The London Resort Development Consent Order

Appendix 12.5 Consultation responses to the 2020 EIA Scoping request

Document reference: 6.2.12.5
Revision: 00

Appendix 12.5 Consultation Responses to the 2020 EIA Scoping Report (Relevant to Terrestrial and Freshwater Ecology)

Registered office: 01285 740427 · www.edp-uk.co.uk · info@edp-uk.co.uk

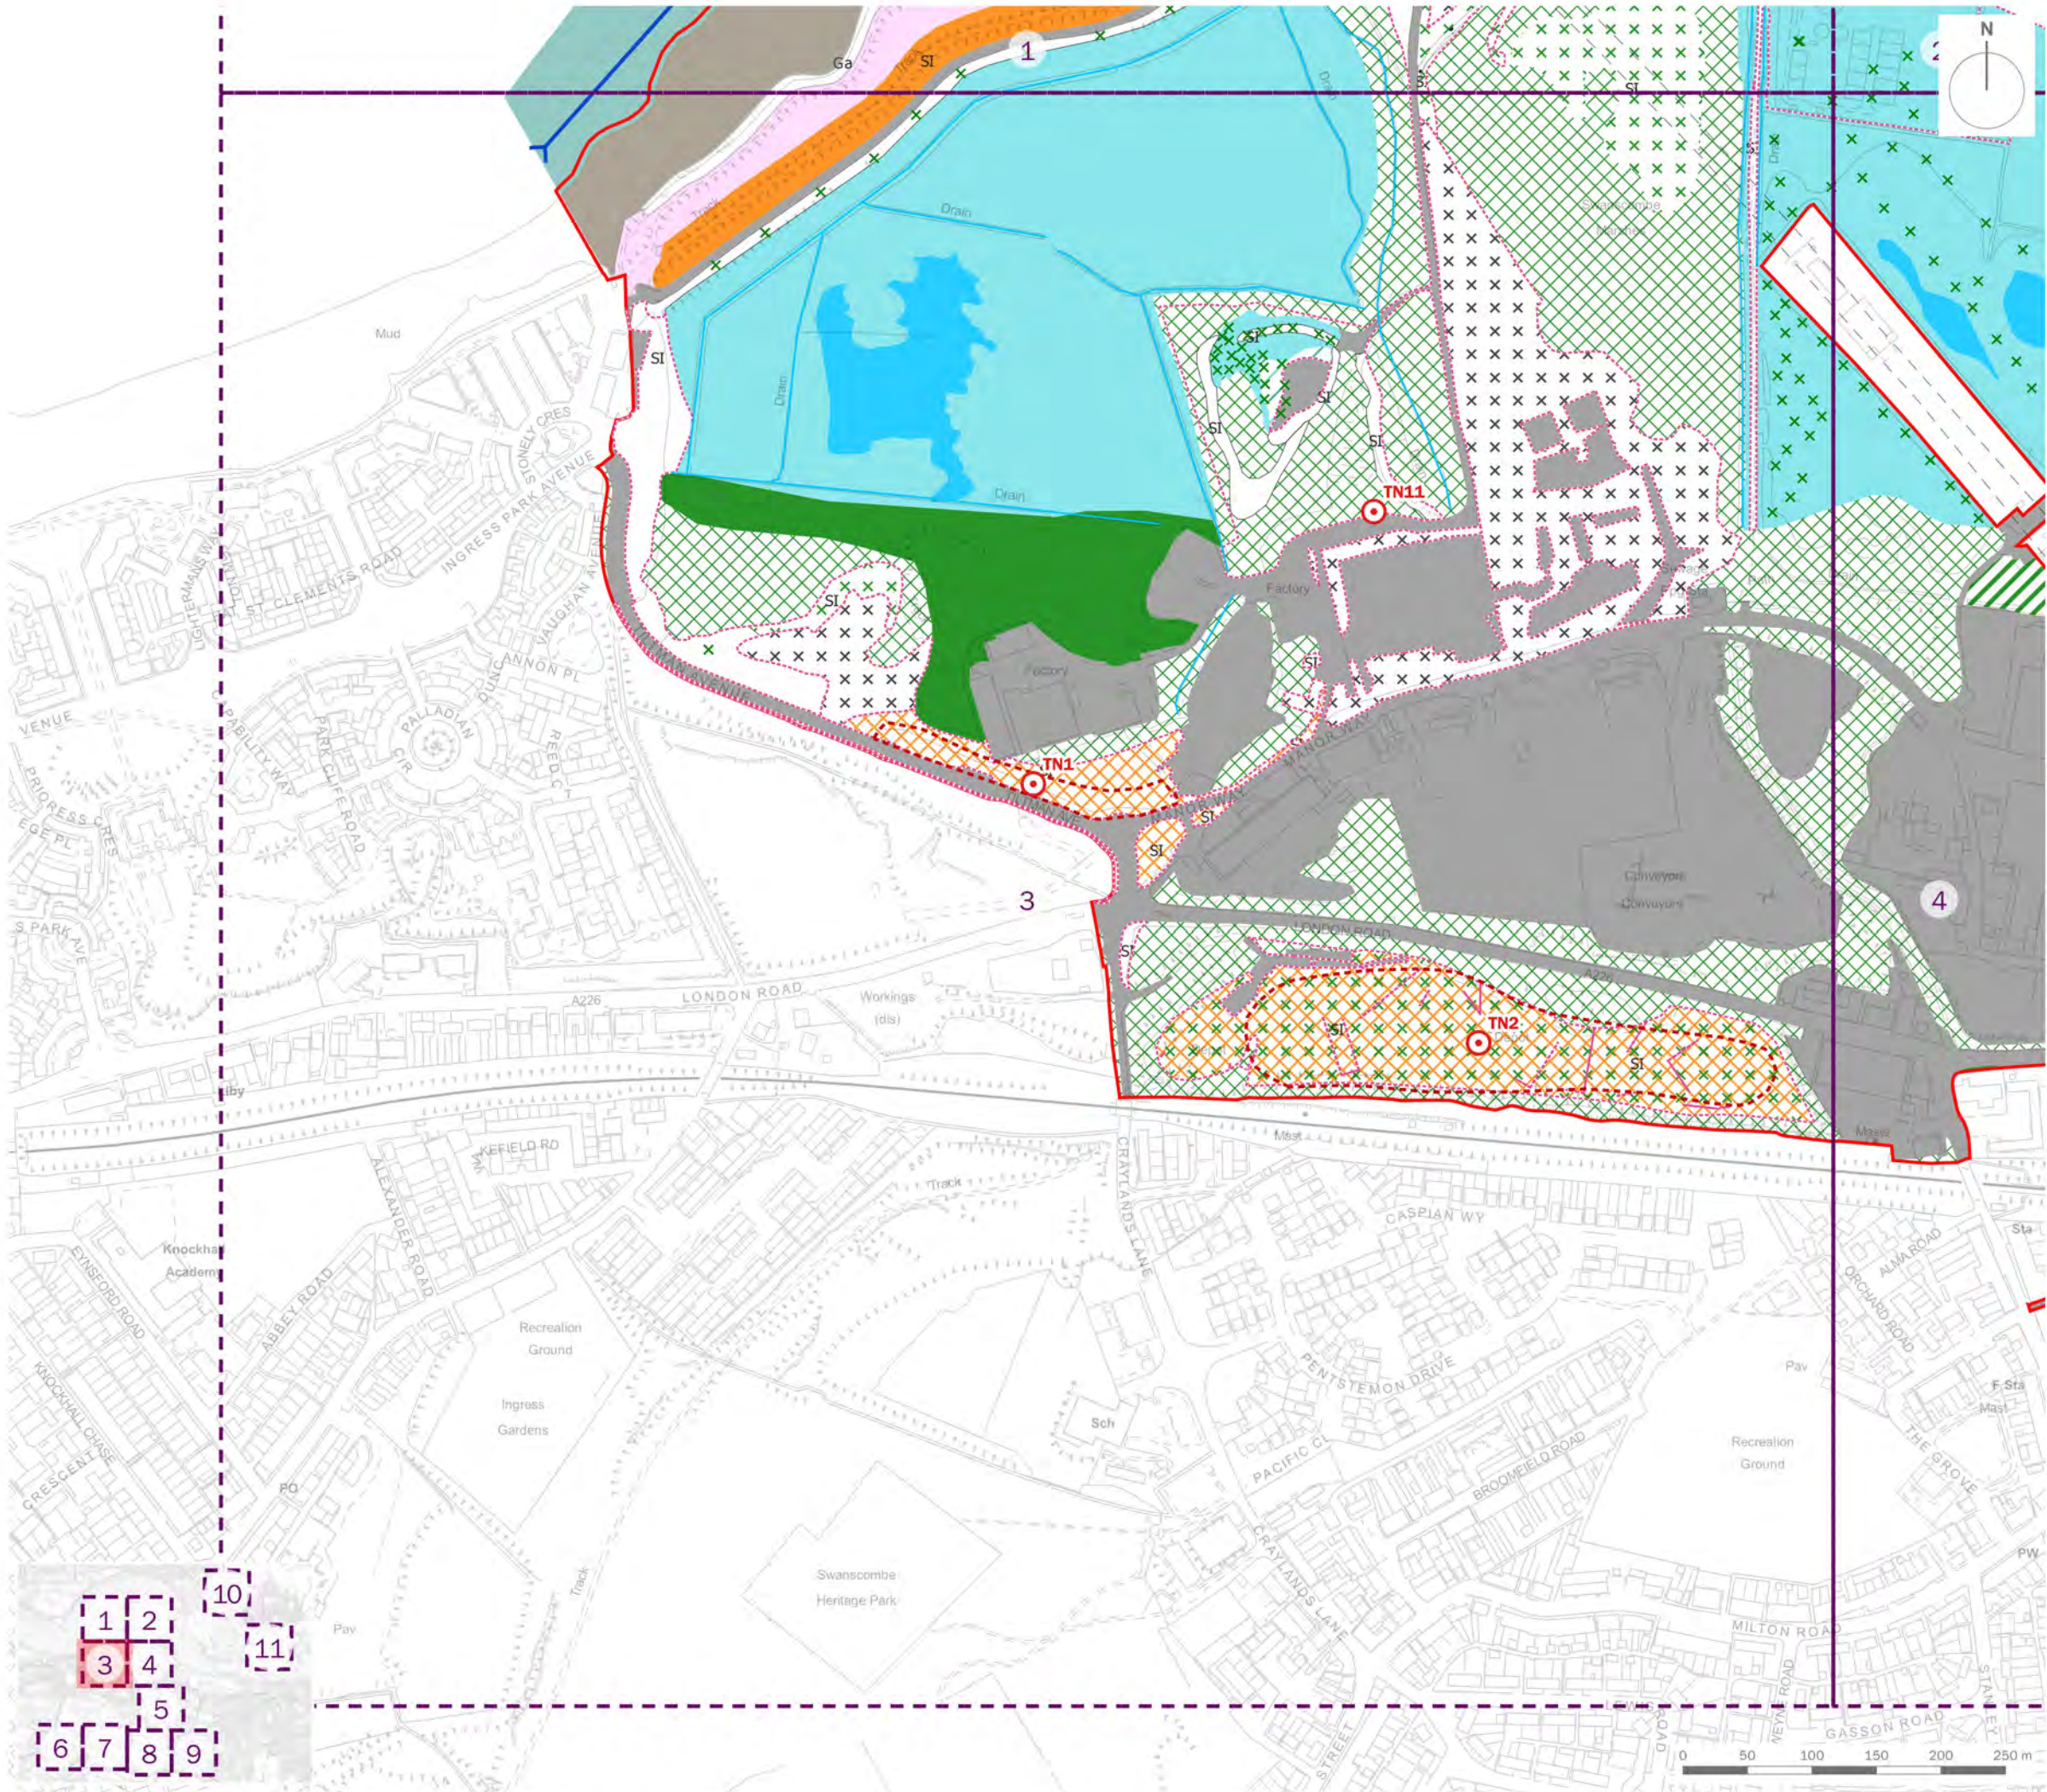
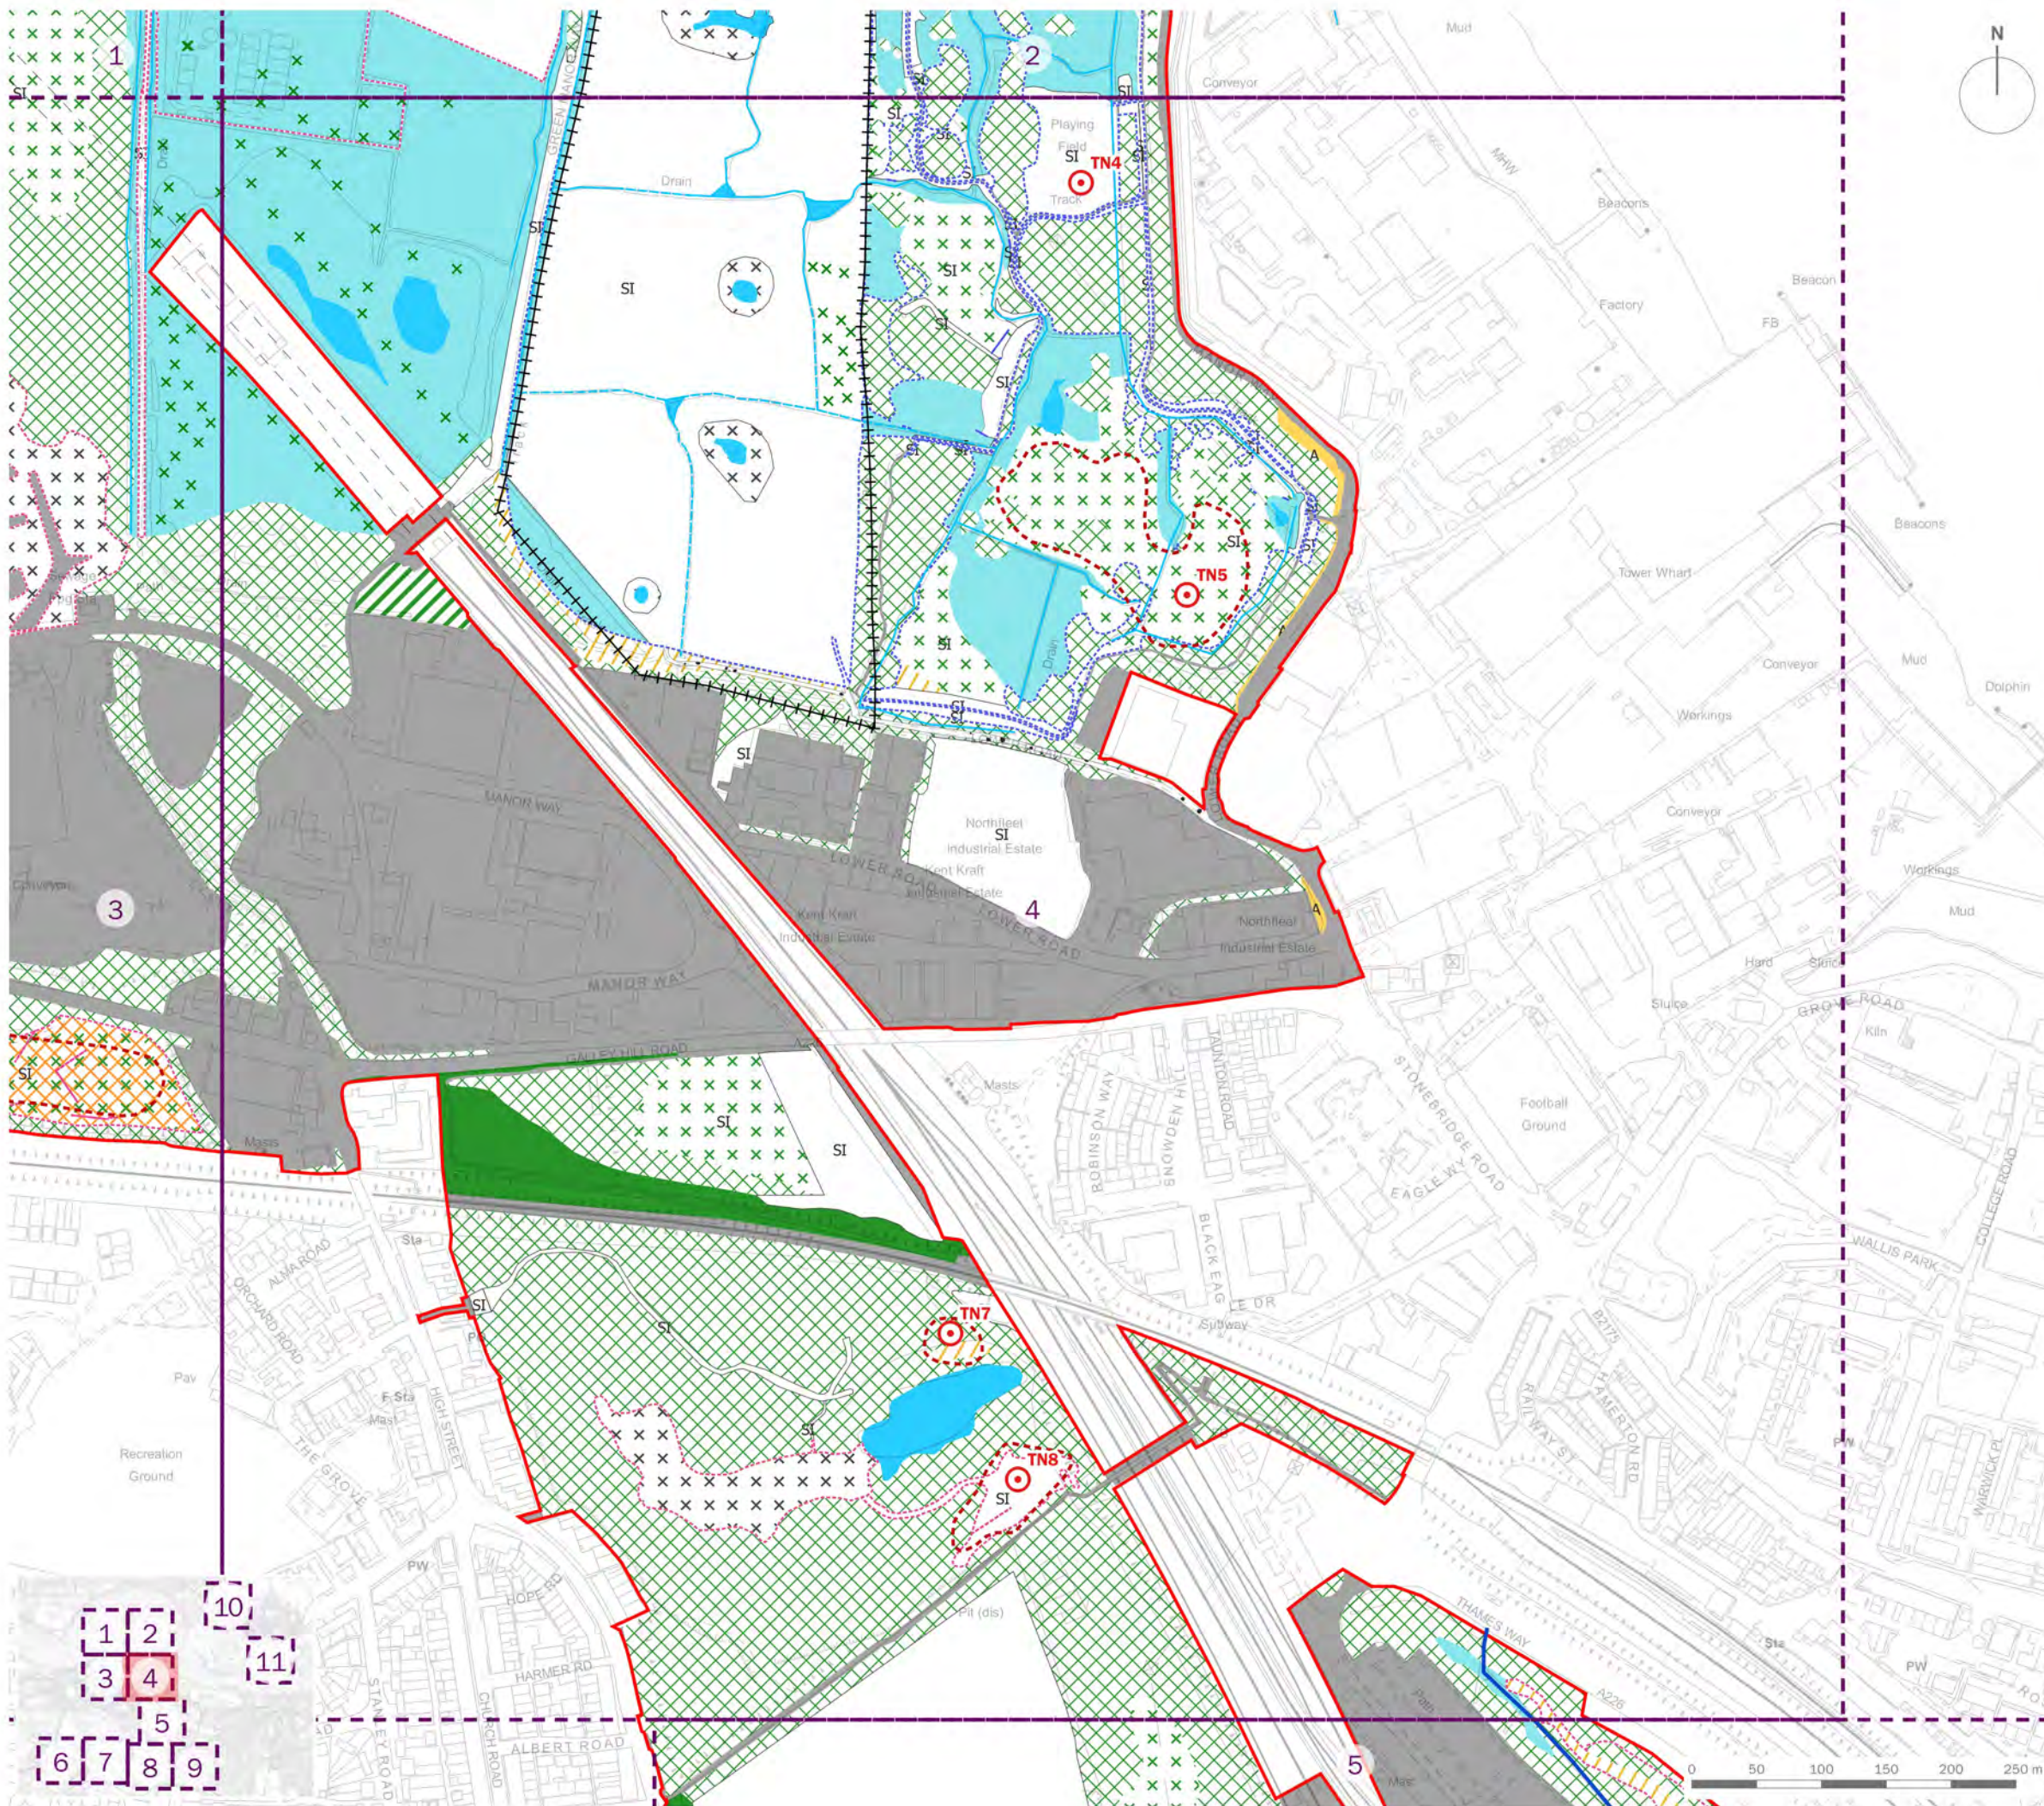
Phase 1 Habitat Plan		Drawing number edp5988_d047 lists the Thames as standing water. It is not and that reference will significantly affect how the Thames is assessed particularly for navigation. Mud will also extend beyond the low tide level.	The Phase 1 Habitat Plan has been updated to show the River Thames as moving water (tidal), with direction of flow indicated. It is acknowledged that mud extends beyond the low tide level, but for the purposes of the Phase 1 Habitat plan, the extent of intertidal mud running to the low tide level is considered sufficient.
	WFD within ES		Reference to the Water Framework Directive (WFD) is spread across three different chapters of the Scoping Report and it is not well cross-referenced which makes it confusing to follow. The terrestrial and freshwater ecology chapter of the ES is one place where the WFD is mentioned.	References to the WFD have been reviewed as part of updating the Environmental Statement ready for submission
